From: Laura Gibbons
Sent: 23 November 2018 13:46
To: Planning.Responses
Cc: Amber Willard
Subject: RE: Planning Consultation on: Y/79/18/HH

Engineers Comments Regarding Surface Water

APPLICATION Y/79/18/HH

Description of Works: Conversion of attached garage and replacement extension

Roof Plan ~ As Proposed

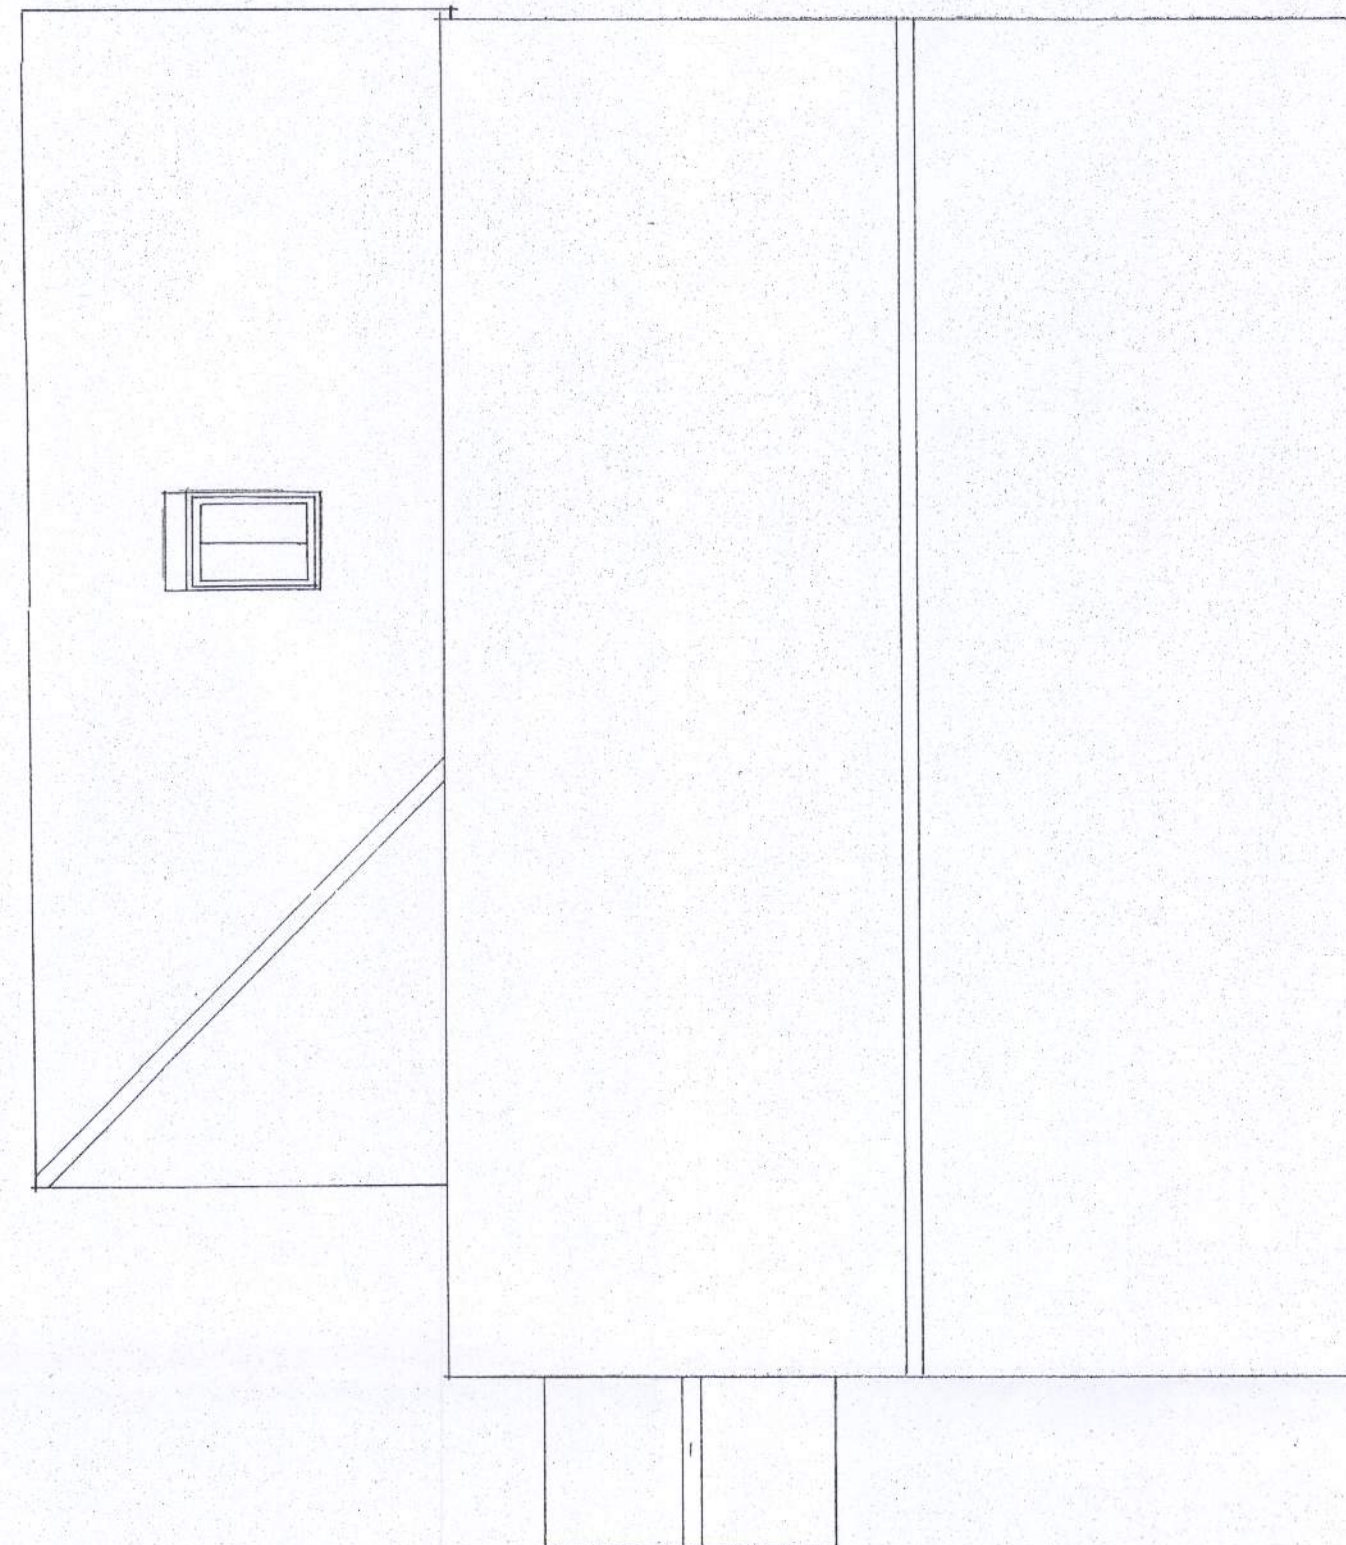
The proposals are for the conversion of the existing garage, a small reduction in roof area is proposed. Any alterations to surface water drainage should be designed and constructed in accordance with building regulations.
